**DRAINAGE LETTER
FOR
7886 RANNOCH MOOR WAY
EL PASO COUNTY, COLORADO
VR262**

RE: 7886 Rannoch Moor Way
Colorado Springs, CO 80908
PCD #: VR262

7886 RANNOCH MOOR WAY
GRADING, EROSION, & SEDIMENT CONTROL PLAN

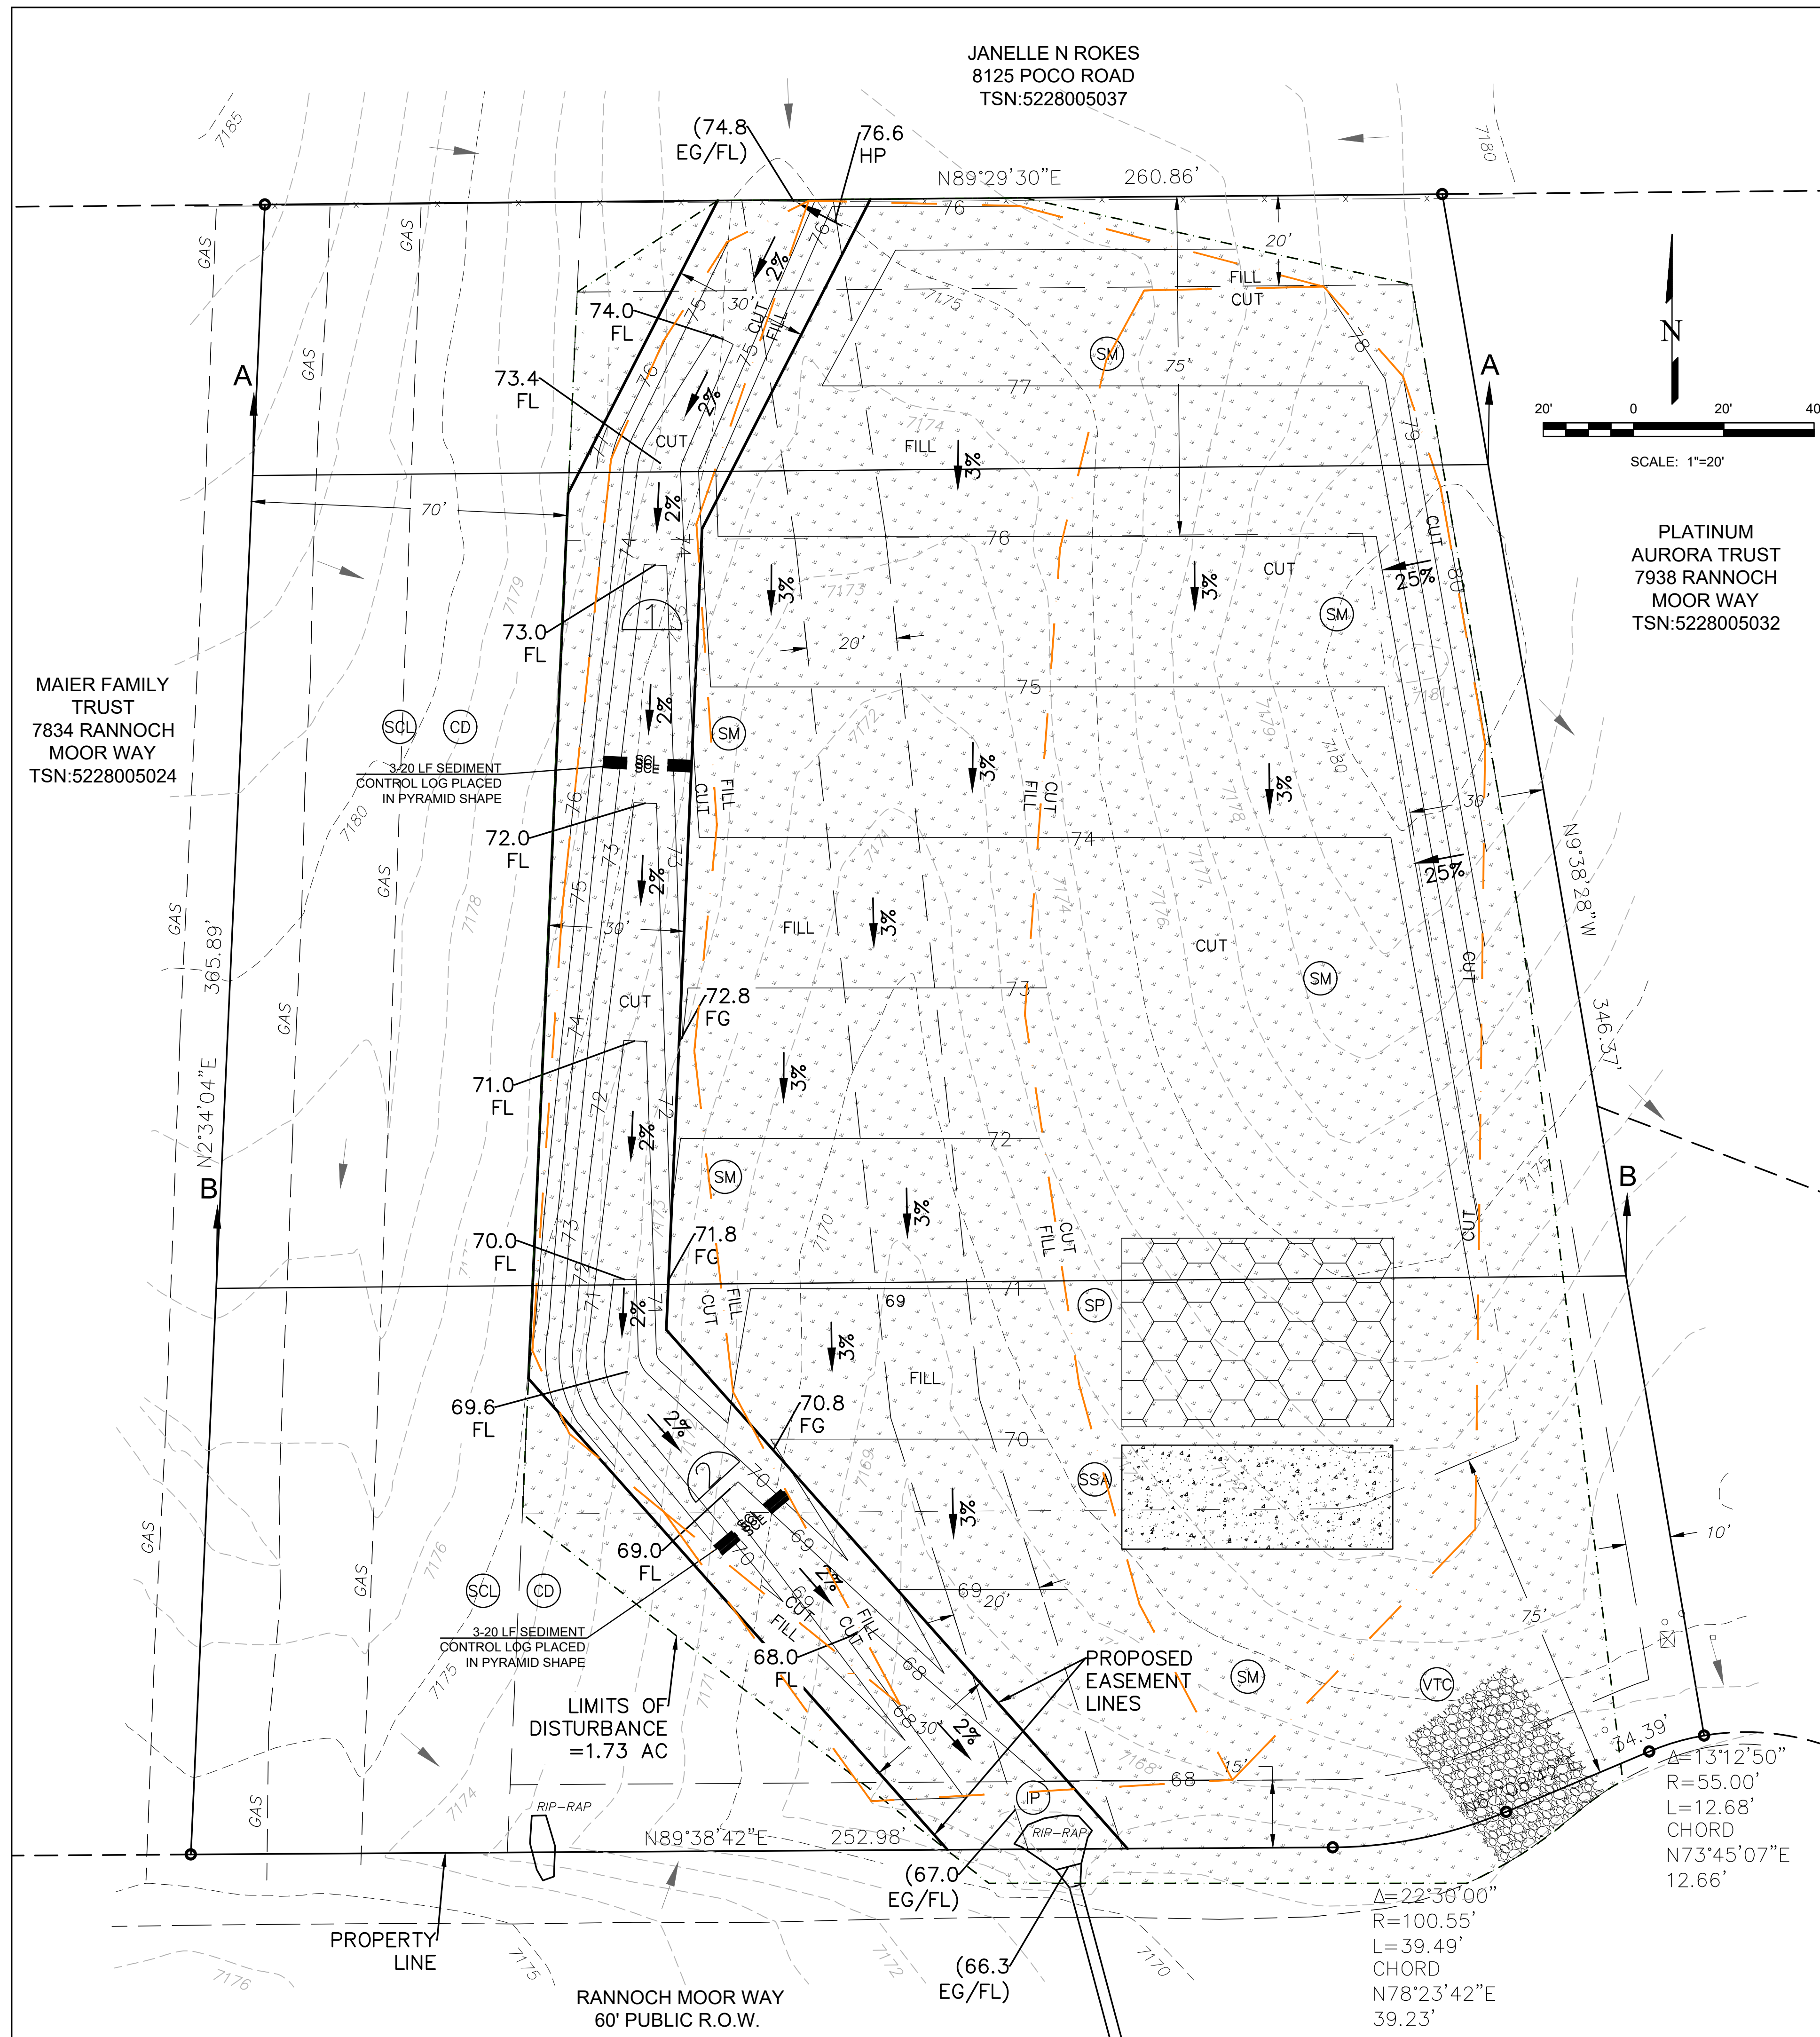
Please see my comment for
General note 7 below. This will
resolve the comment below.

Future use is a home that will be
constructed here, please have a
Geo-technical engineer determine
the recommendations and
restrictions for everything that is
needed including compaction level
and placement of back fill layers
etc. and monitoring the
embankment construction to ensure
the new home is not going to fall
apart, the Geo-technical Engineer
may want to recommend the new
home foundations to be installed on
the ground prior to embankment or
even to lower level.
Please indicate the Geo-technical
Engineer recommendations and
restrictions here.

Add the following "The GEC Permit and the"
